Inspector's Report ABP RL.307272-20

Whether the installation of a timber frame Garden Room / Gym, (floor area when fully insulated will be less than 25 sq.m.) with pitched roof with a height less than 4 metres is or is not development or is or is not exempted development.

Rose Cottage, Brackenstown Road, Swords, Co. Dublin, K67 H4F8.

Proposed Site Layout Plan
 1 : 250

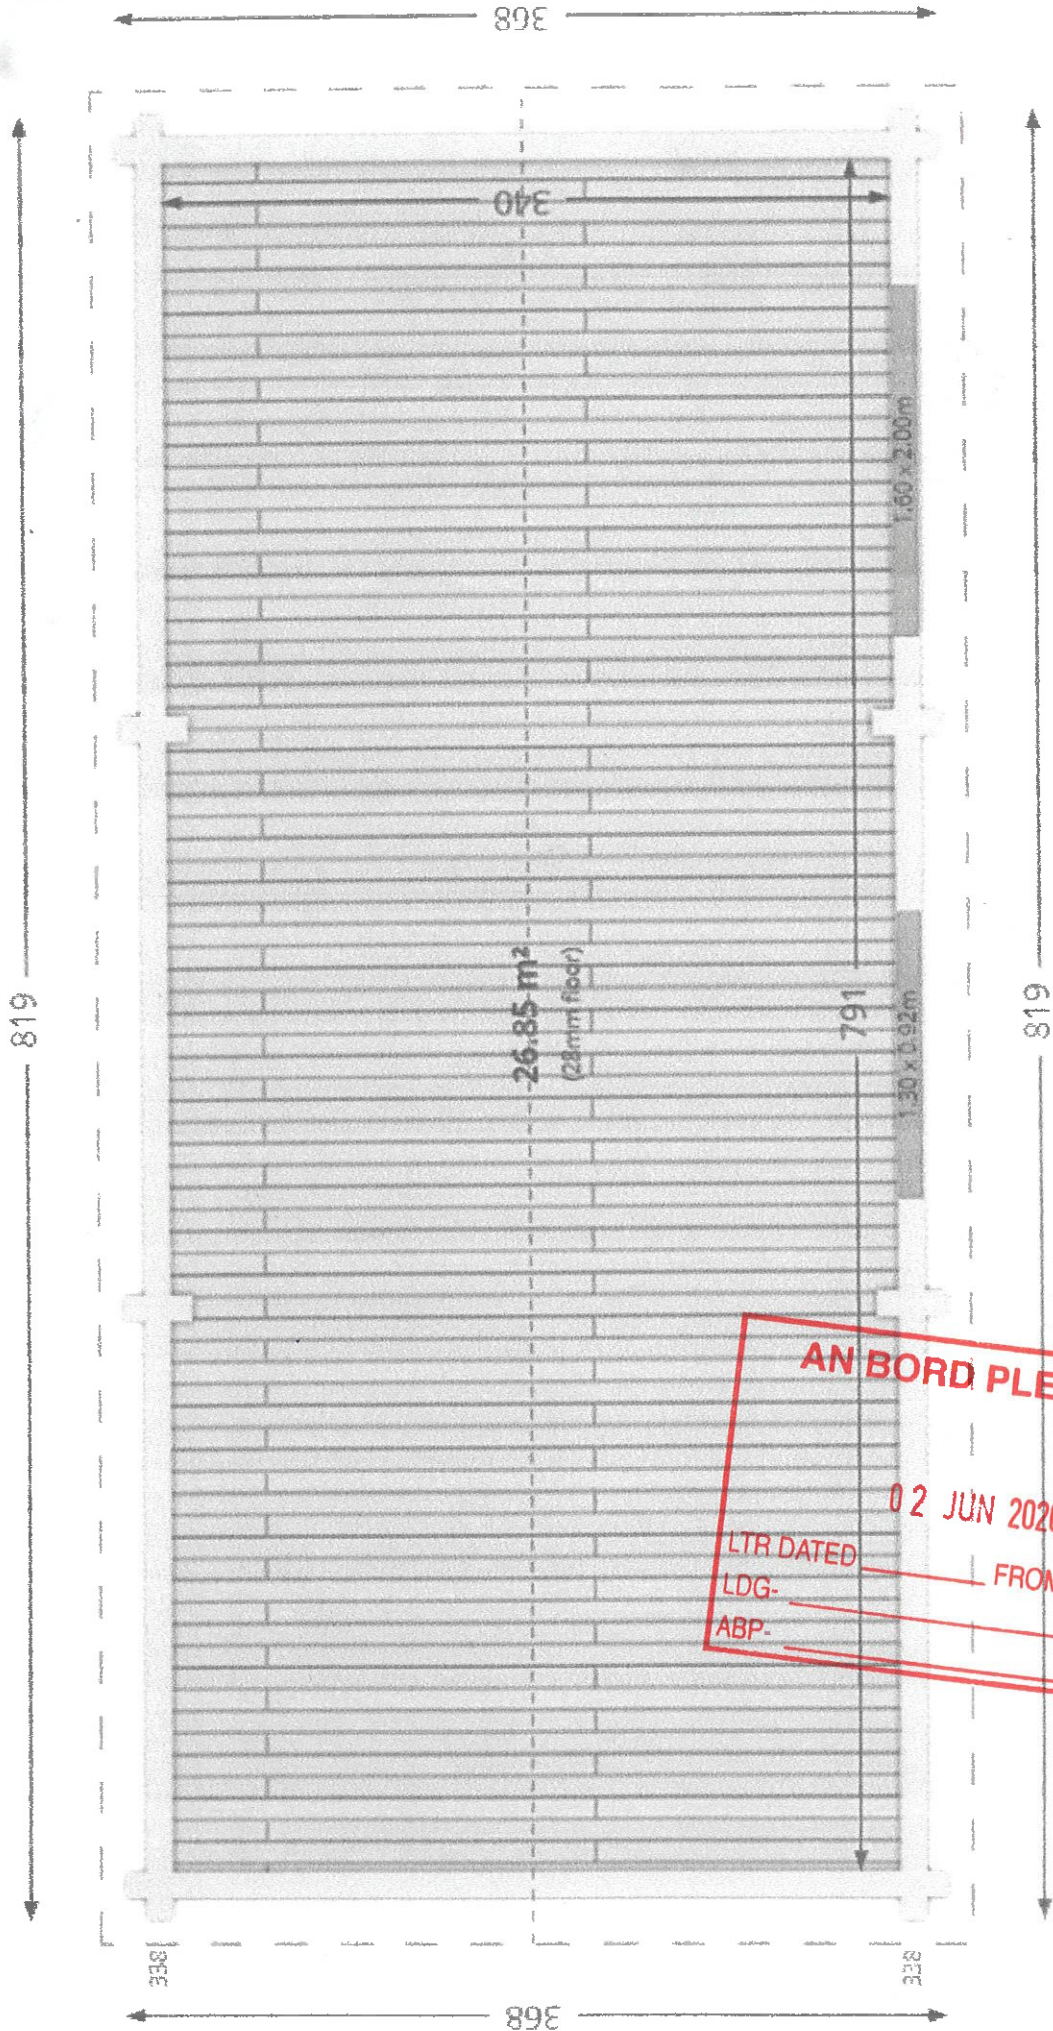
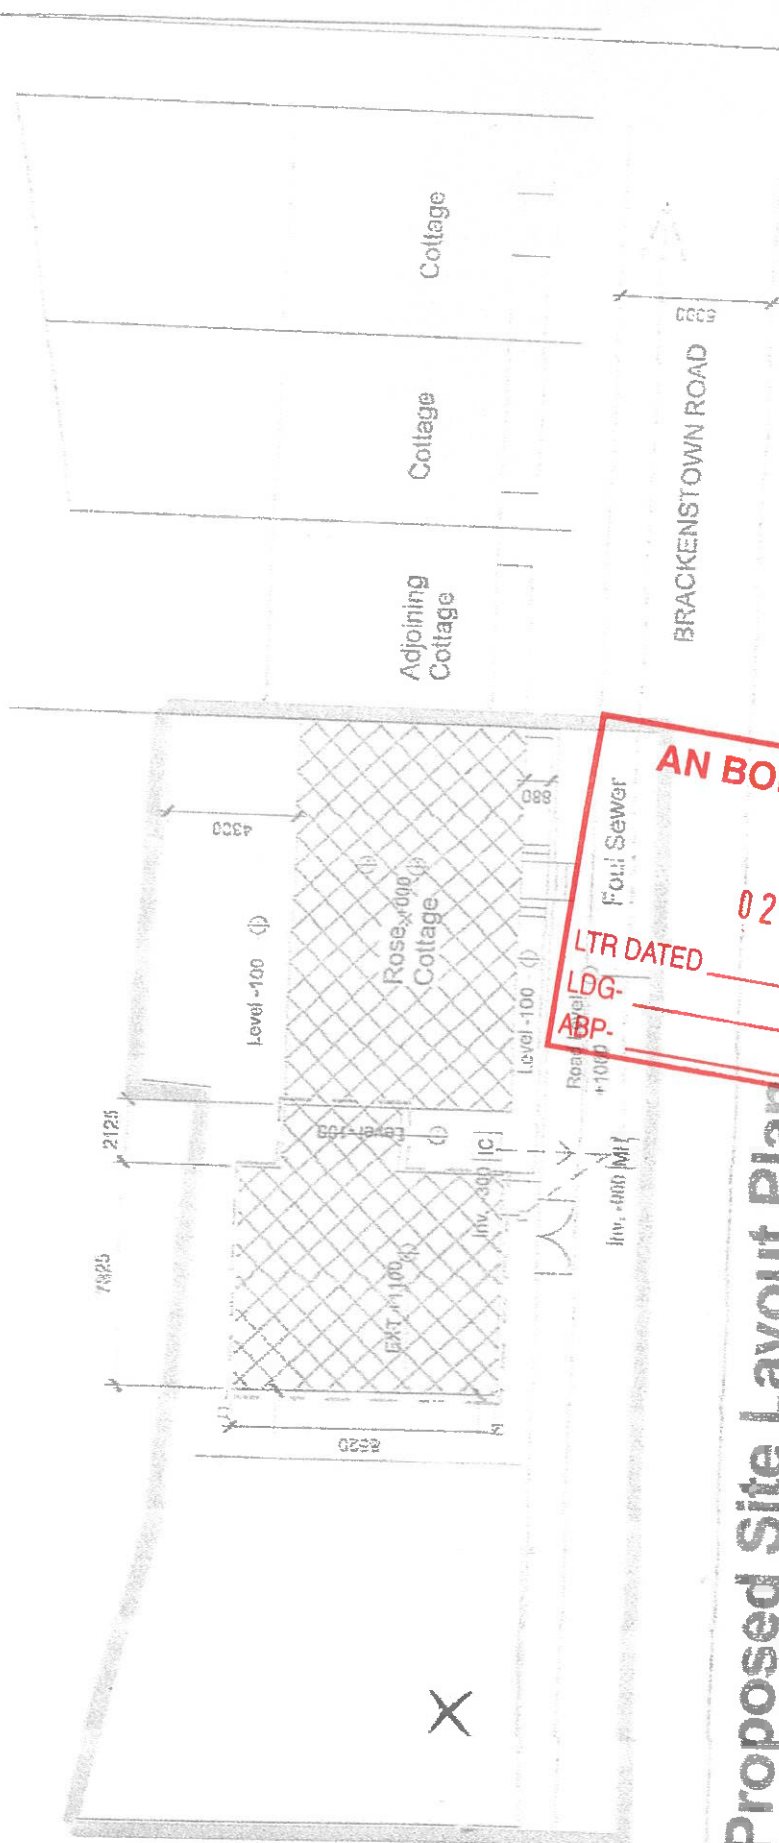
- The proposal is for a timber framed, fully insulated garden room/gym with a pitched roof less than 4m and a floor area of less than 25 sq.m.
- The proposal will not be located forward of the front wall of the house, however its precise location cannot be verified. The location of the proposal is indicated with an 'X' on the Site Layout Plan submitted.

8.3.4. The referrer's 'Case for Appeal' document submitted states that the proposed structure will not be placed forward of the front wall of the house. The Proposed Site Layout Plan details the location of the proposed structure with an 'X' to the side of the dwelling. The precise location and layout of the proposed structure is not detailed. I am, thereby, unable to measure the distance between the proposed structure and the front wall of the house. I note the Planning Authority in its assessment of the referral states that the location of the proposed structure cannot be verified based on the details submitted. Notwithstanding this, given the Referrer's confirmation that the proposed structure will not be placed forward of the front wall of the house, I am satisfied that the proposal complies with Condition No. 1.

NOTE: Hand-Drawn Plans

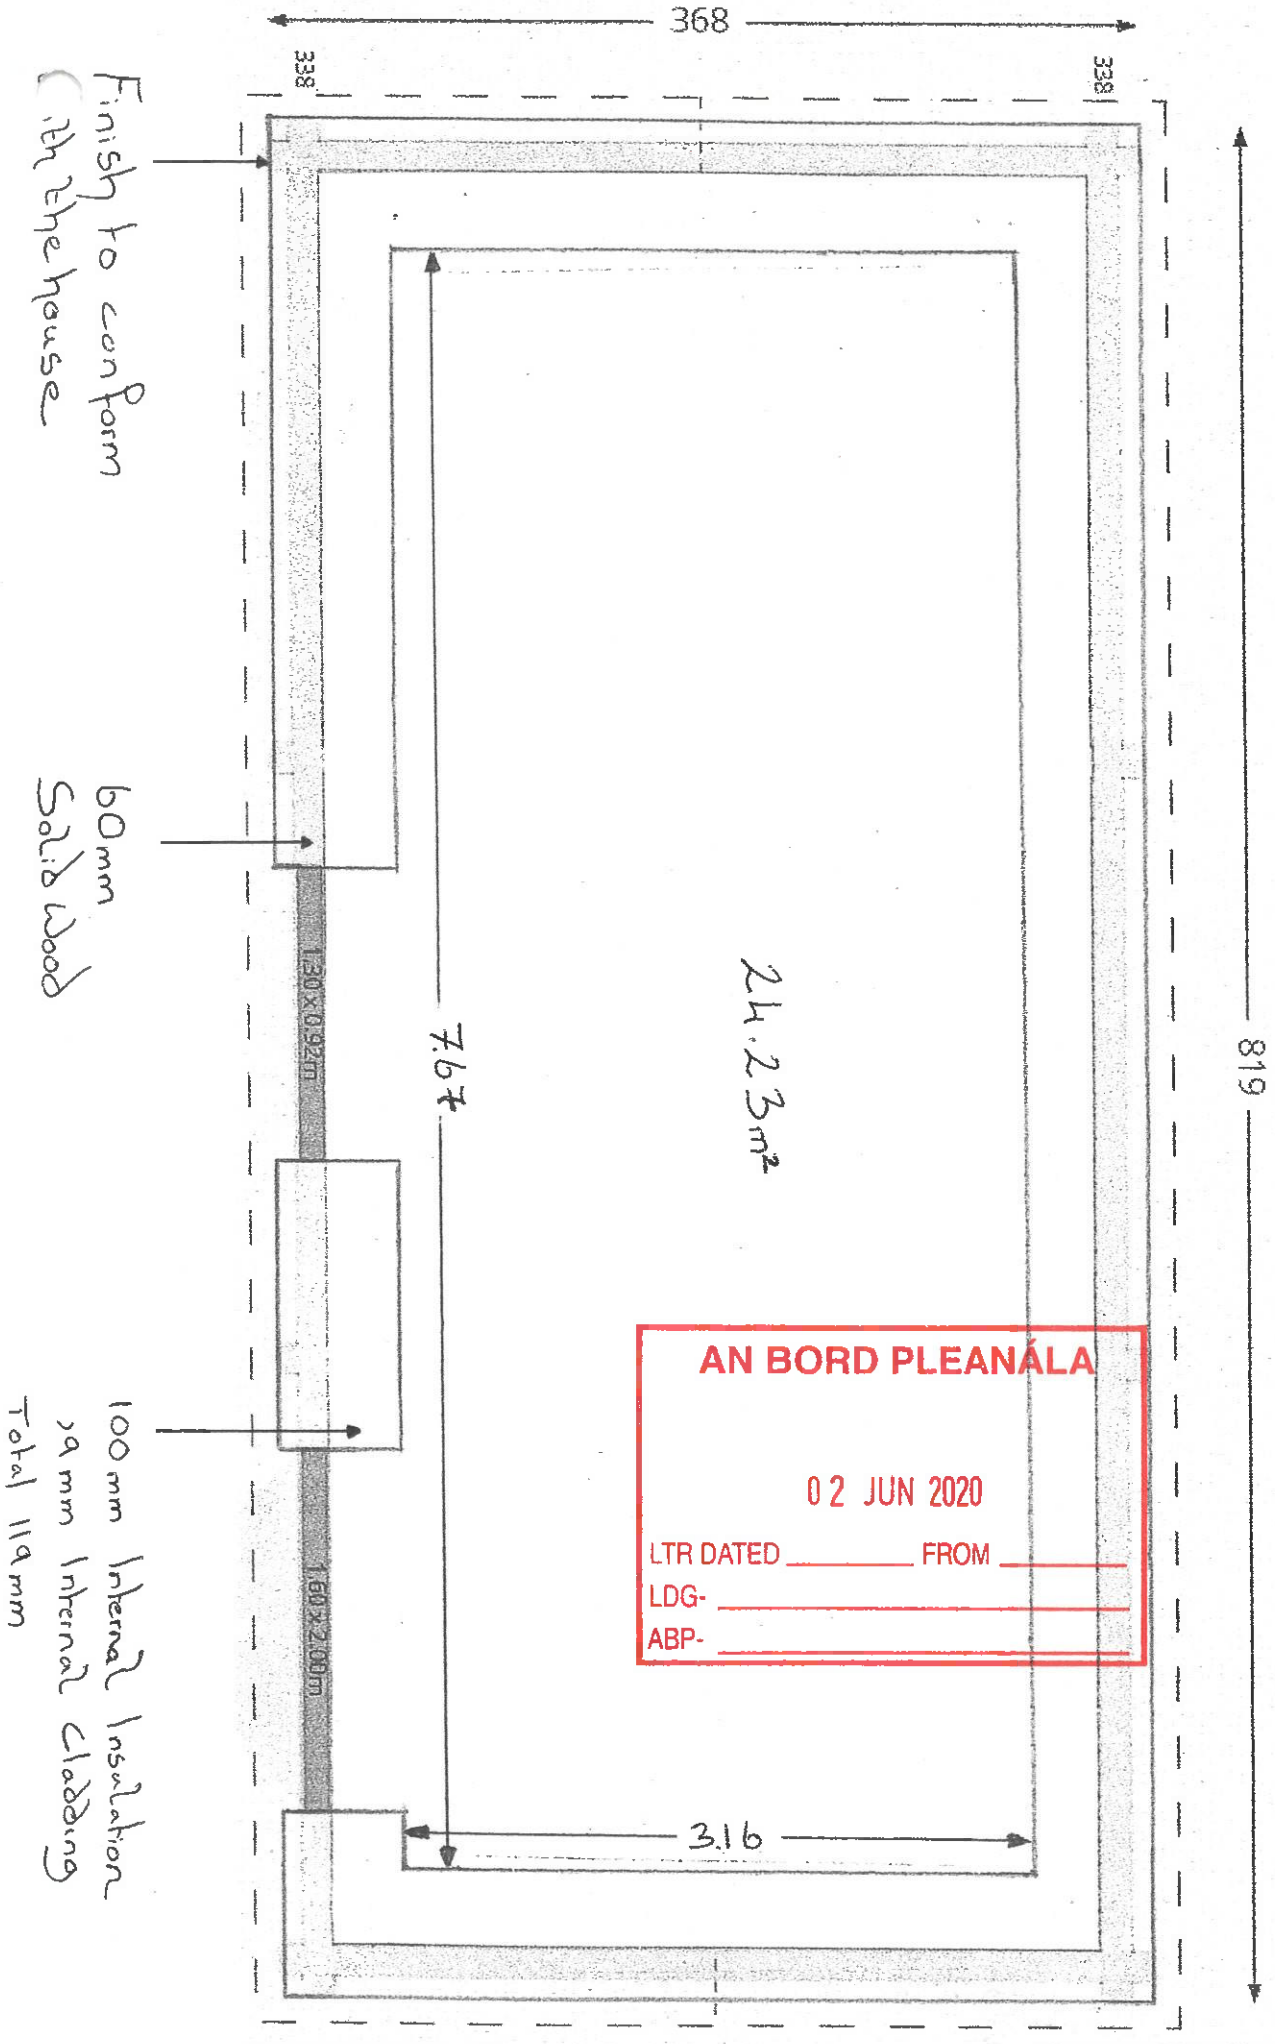
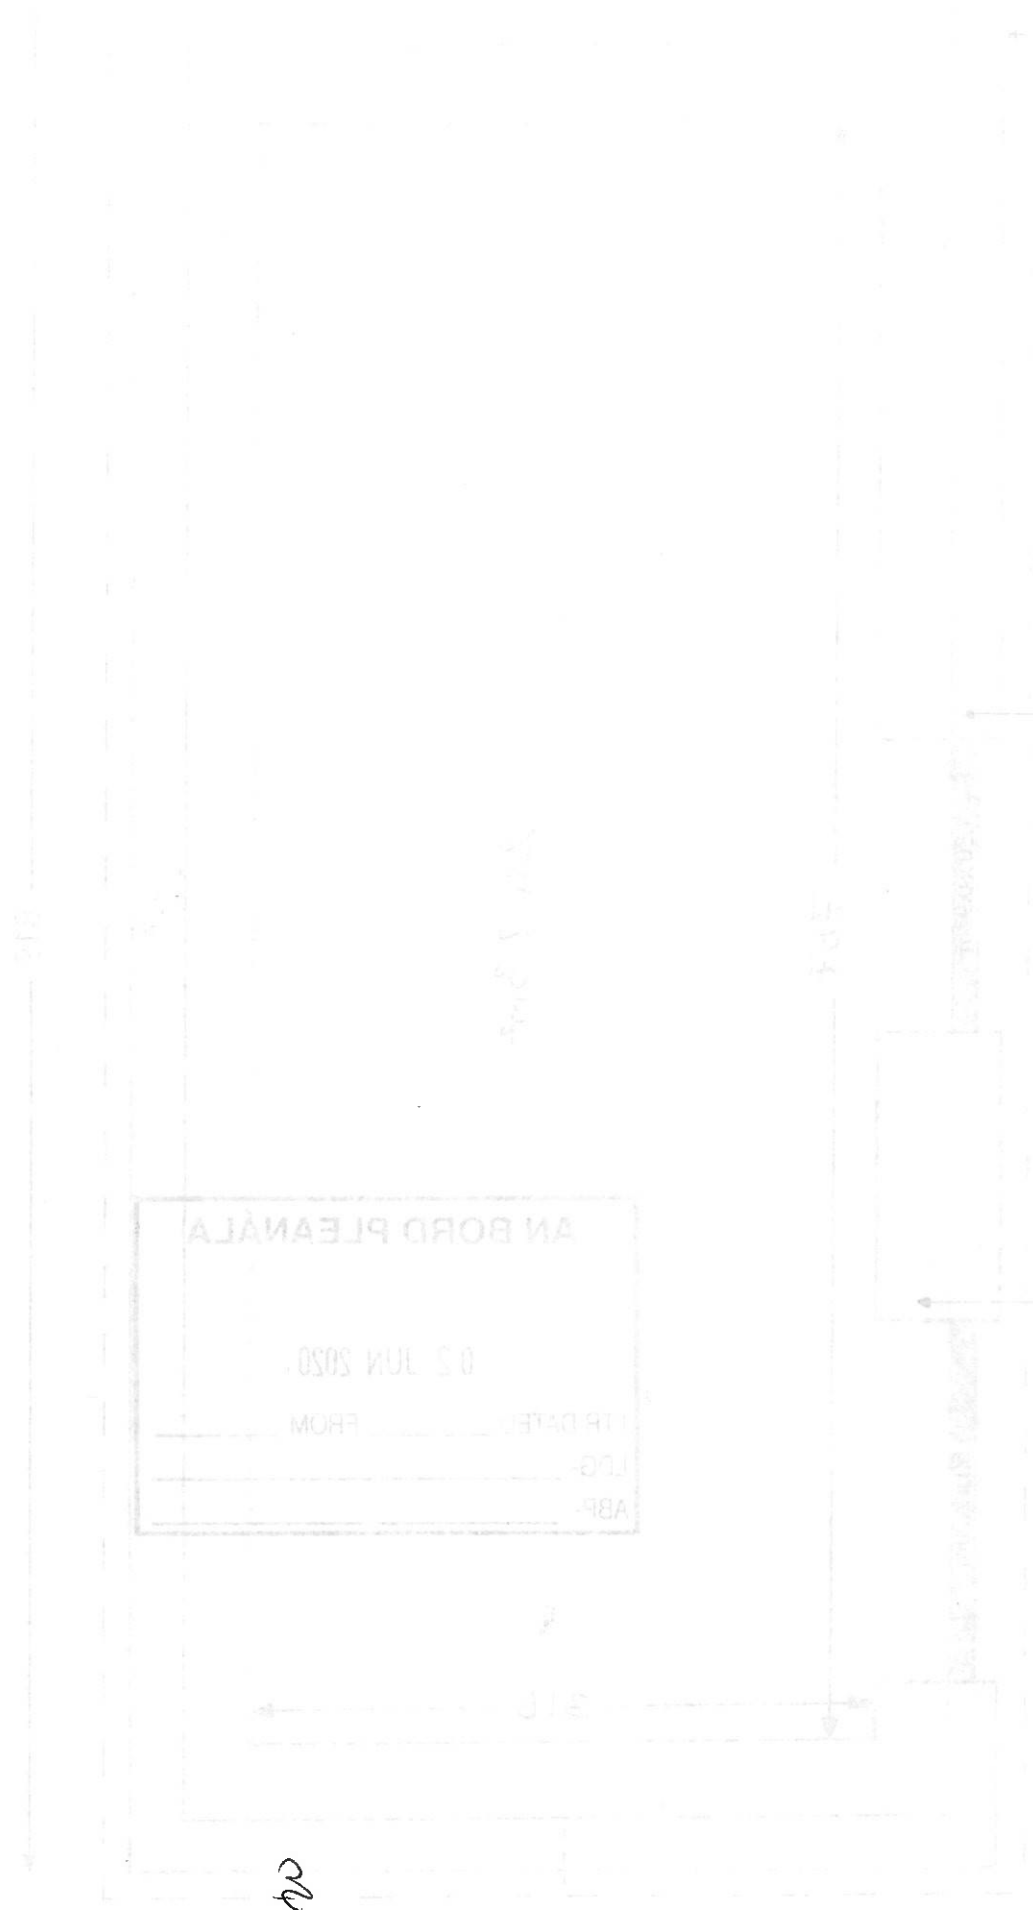
- The submitted drawings indicate the floor area of the proposed structure will be 26.85 sq.m. This exceeds the 25 sq.m. allowance as specified under Limitation No. 2 of Class 3 Schedule 2 Part 1 of the Planning and Development Regulations 2001 (as amended). The size of the proposed garden room / gym is therefore NOT exempted development.

- 8.3.6. The Planning Authority in its assessment of the referral states that the drawing submitted of the proposed structure indicates a floor area of 26.85 sq.m. and that this exceeds the 25 sq.m. floor area limitation under Condition No. 2 of Class 3. On this basis, the Planning Authority state that the size of the proposed garden room / gym structure is NOT exempted development.

- 8.3.7. The Referrer states in the 'Case for Appeal' that the floor area of the proposed structure will be less than 25 sq.m. and will be the only structure in the garden. The Referrer states that the proposed structure will have 100mm internal insulation and that the figure of 26.85 sq.m. shown on the floor plan is the floor area excluding the insulation and internal cladding. The Referrer clarifies that when the insulation and internal cladding are added to the internal wall, the internal floor area of the proposed structure will be 24.23 sq.m. The Floor Plan submitted with the referral details the provision of 100mm internal insulation and 19mm internal cladding to the internal walls of the proposed structure. The Floor Plan details the internal measurements of the proposed structure as having a length of 7.67m and width of 3.16m, thereby providing an internal floor area of 24.23 sq.m. I note that the floor plan submitted is hand drawn and a scale is not given.

8.3.10. Having regard to the Boards Order in this precedent referral and the definition of "gross floor space" as defined in Article 3 of the Regulations, I consider it appropriate that the gross floor area of the proposed structure should be assessed. Given that the internal floor area of the proposed structure will be 24.23 sq.m. and the Referrer's confirmation that the proposed structure will be the only such structure within the curtilage of the house, I am satisfied that the proposal complies with Condition No. 2.
